**Consultation Response from KC,
Highways Development Management**
2026/91472 101, New Street, Huddersfield, HD1 2TW
Alterations to first floor store to form two apartments
Date Responded: 03/09/2026
Responding Officer: CNB
Responding Ref: K5-7SW/32

This application is for alterations to a first-floor store area above a retail development to form 2 residential dwellings. The site is on New Street, a part of the Huddersfield town centre pedestrianised zone and access is to be on to Corporation Street.

Level 1 Floor Plan
1 : 50

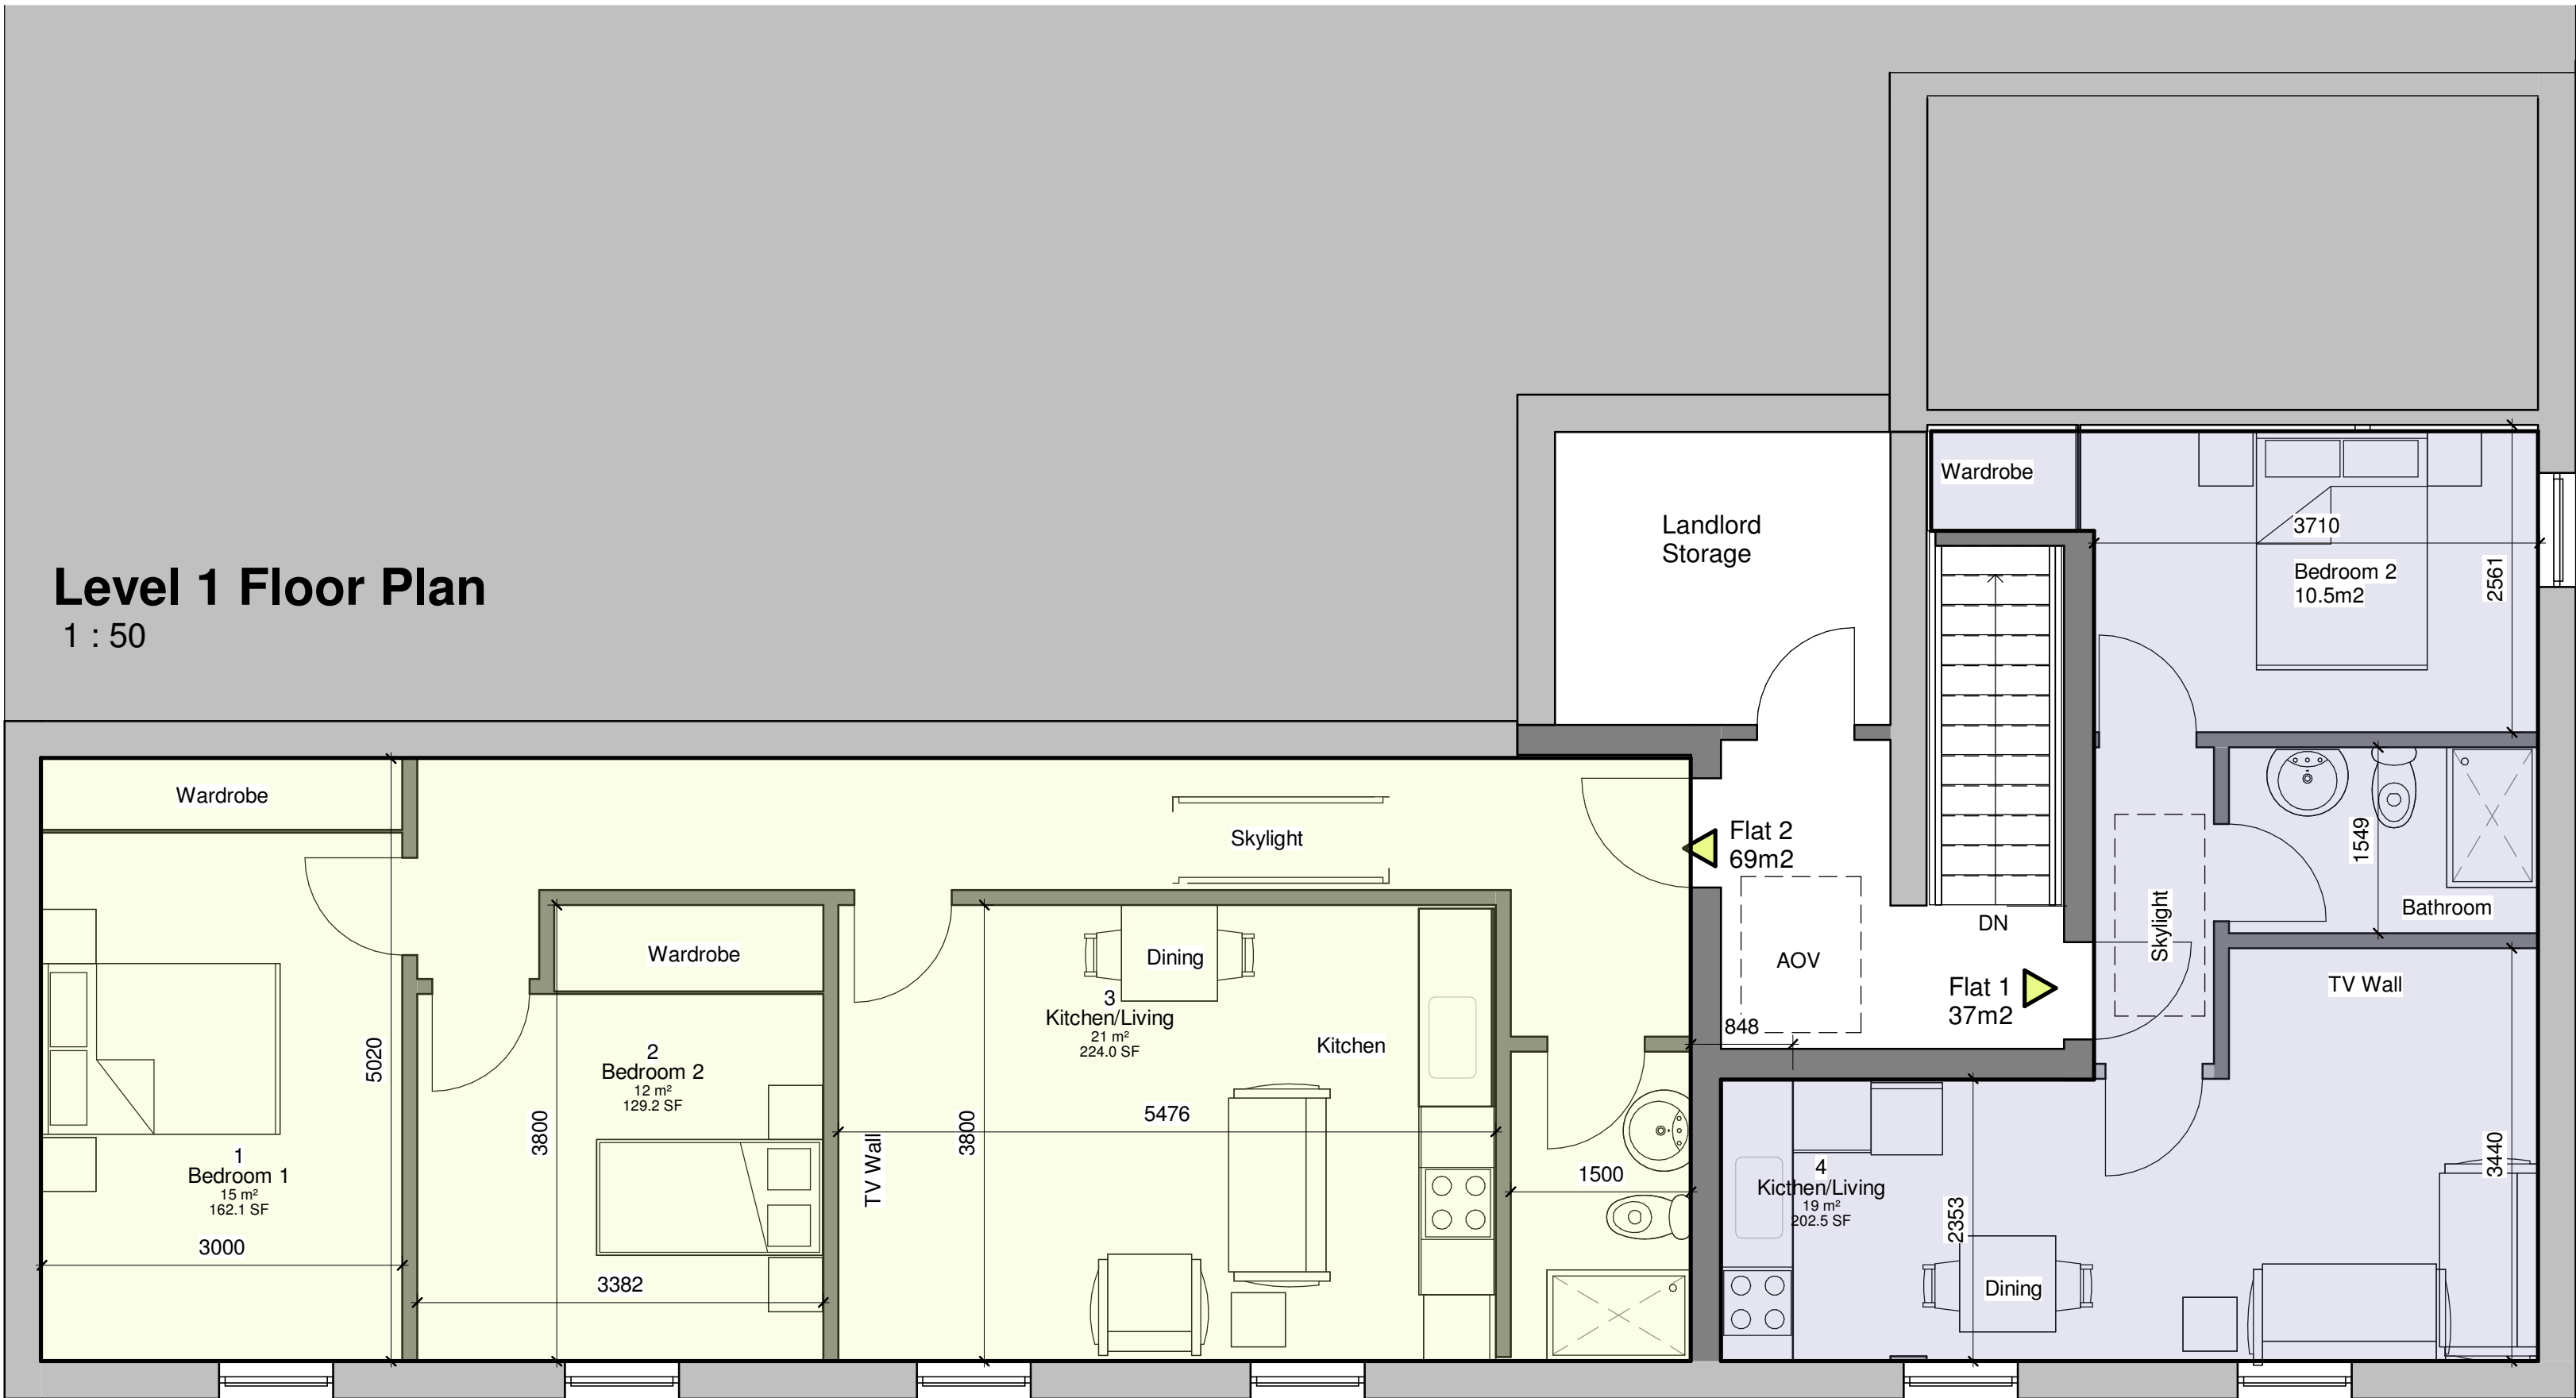
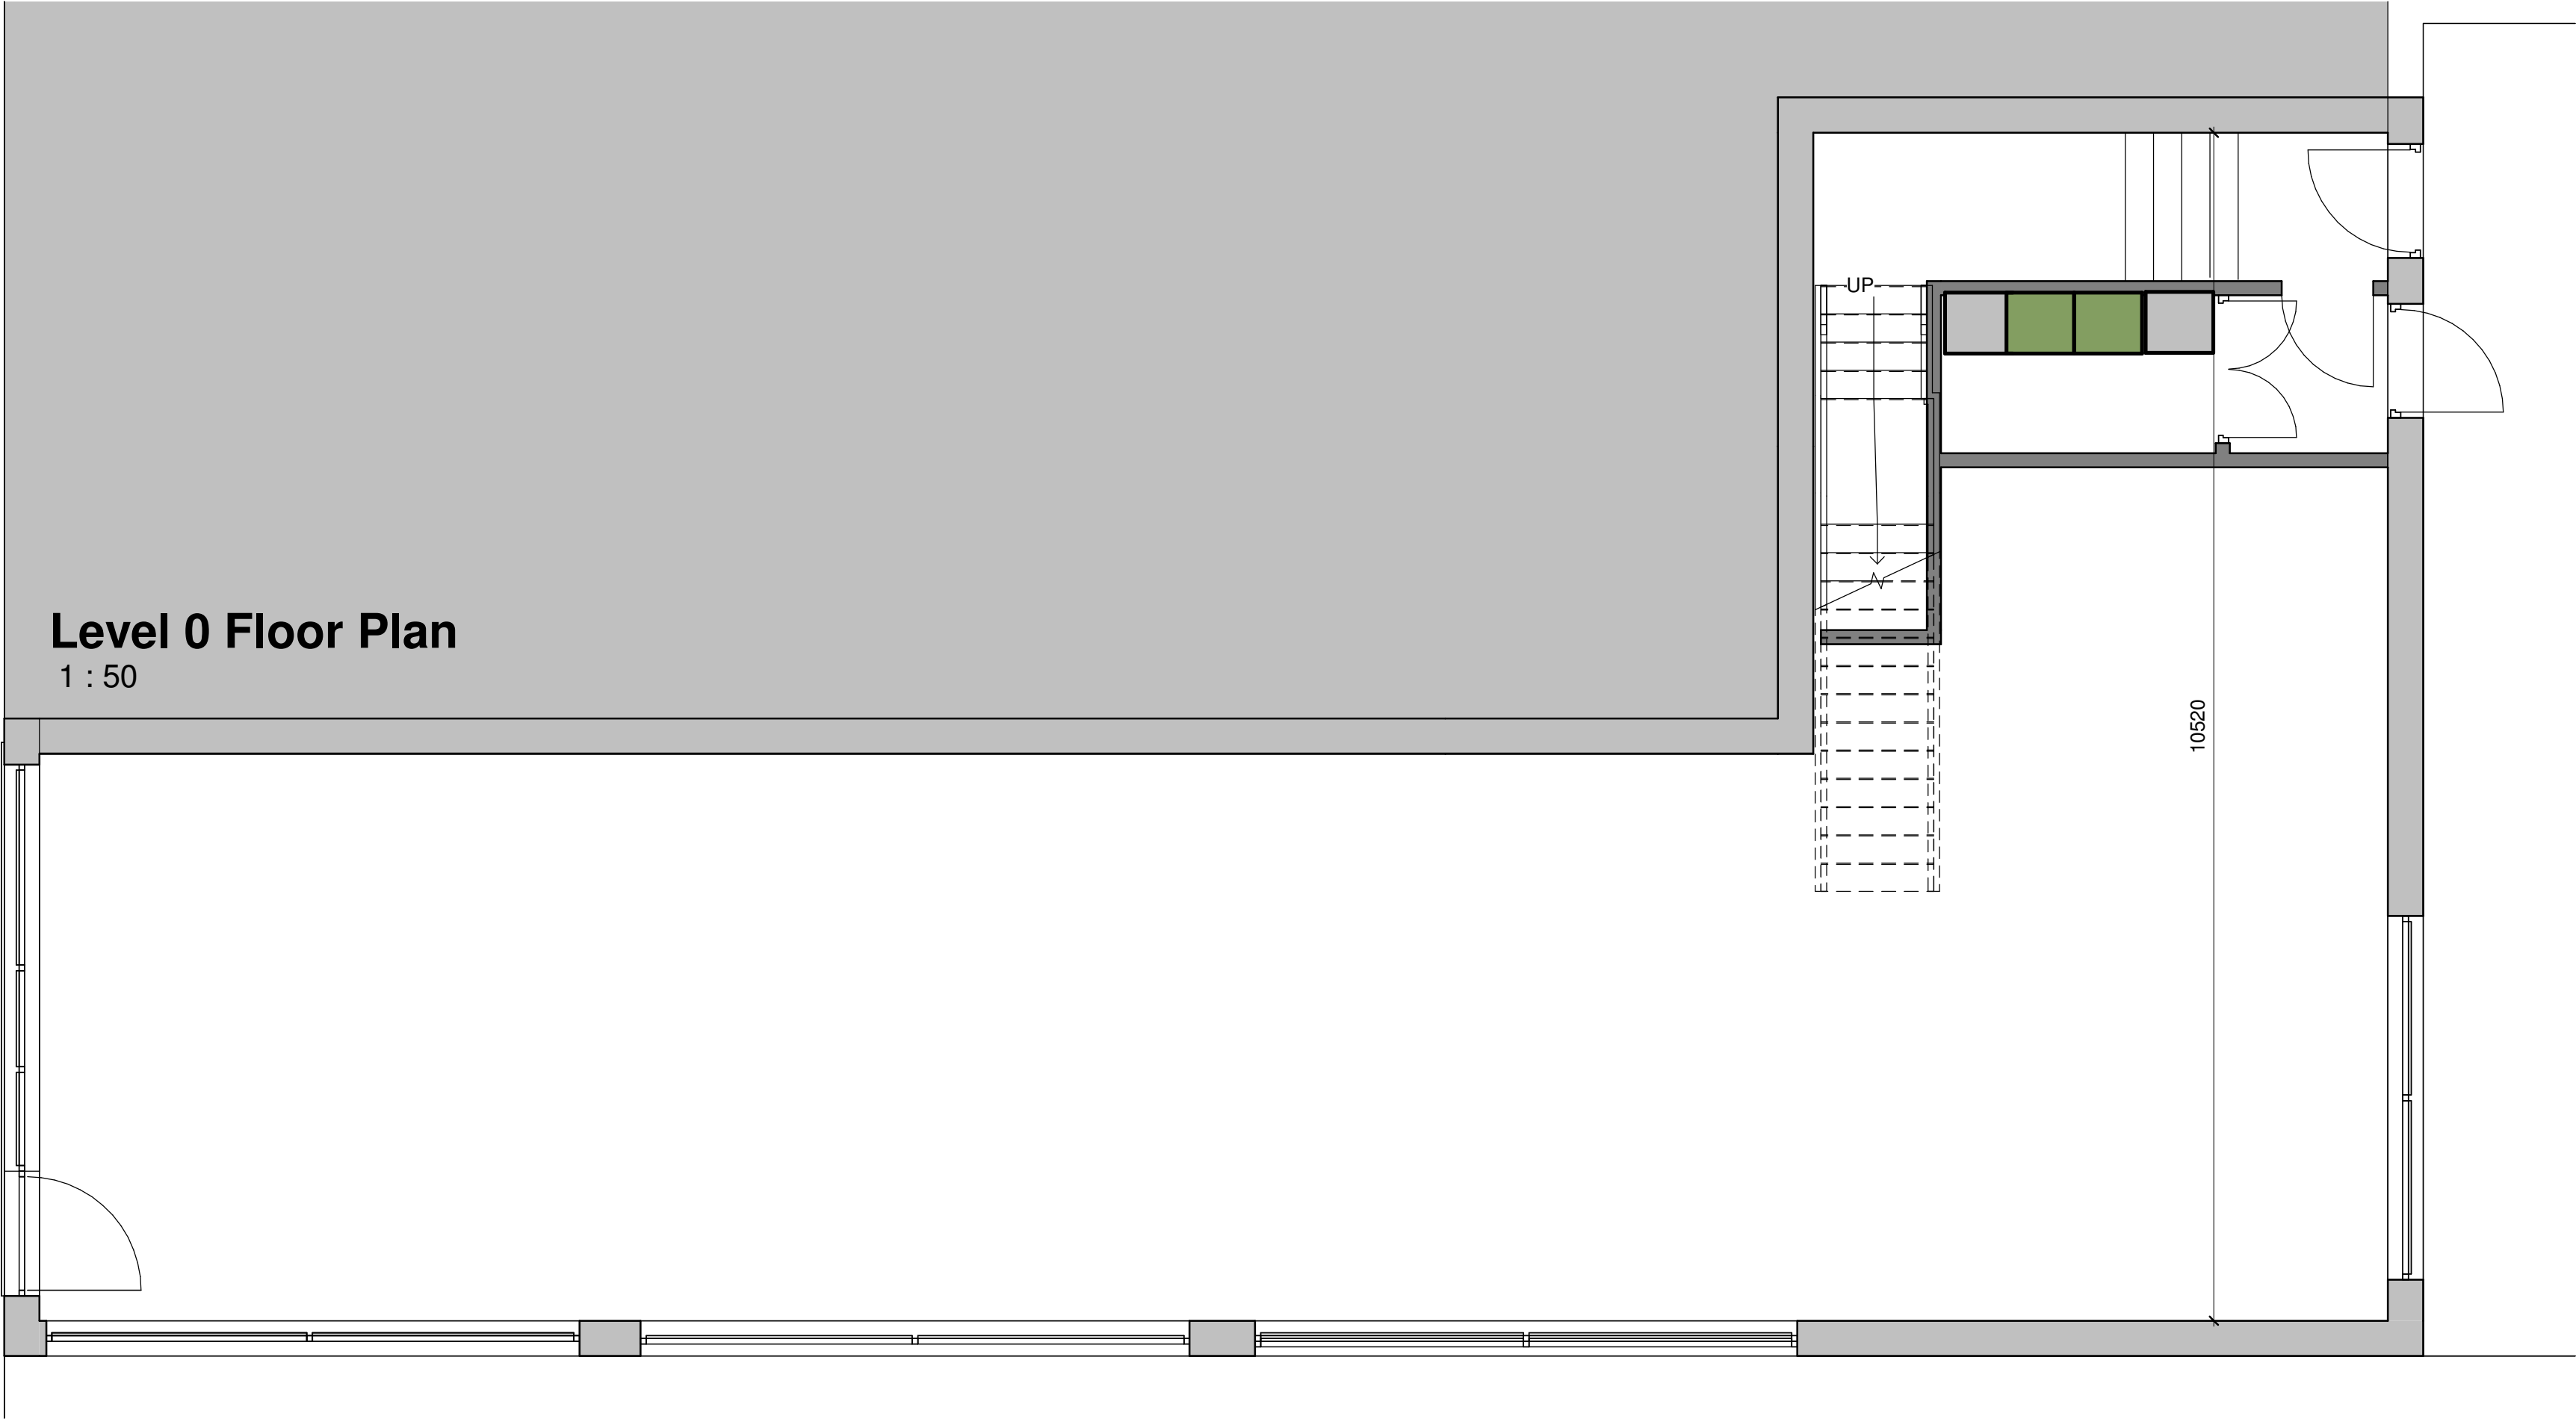
A waste bin storage room is indicated on drawing No UD-640 Proposed Floor Plan, but no collection presentation point is included. We would need to know how collection would be made and who would have the responsibility for returning the bins back to the bin store after collection so that they didn't cause an obstruction to the footway or highway for road safety reasons. This may require a waste management plan (WMP) which should contain details of the aforementioned responsibilities, including contact details, and provide information for where the bins will be left for collection, this would need to be in such a place that they didn't obstruct the access to the site, or the adopted footway or highway.

Consultation with colleagues in the Kirklees Waste Strategy Team have indicated that collection presentation may be acceptable from the corner of the building at Princess St/Corporation St, however the applicant will need to ensure that the bins are returned to the bin store soon after emptying and not be left all day and this will need including within the conditioned waste management plan.

Before development commences, details of suitable storage, bin presentation points, responsibilities for moving bins between the storage point and collection point before and after collection (including timeframes for the return of the empty bins) and access for collection of wastes from the **dwelling/premises** hereby approved shall be submitted to and approved in writing by the Local Planning Authority. The approved details shall be provided before first occupation and shall be so retained thereafter.
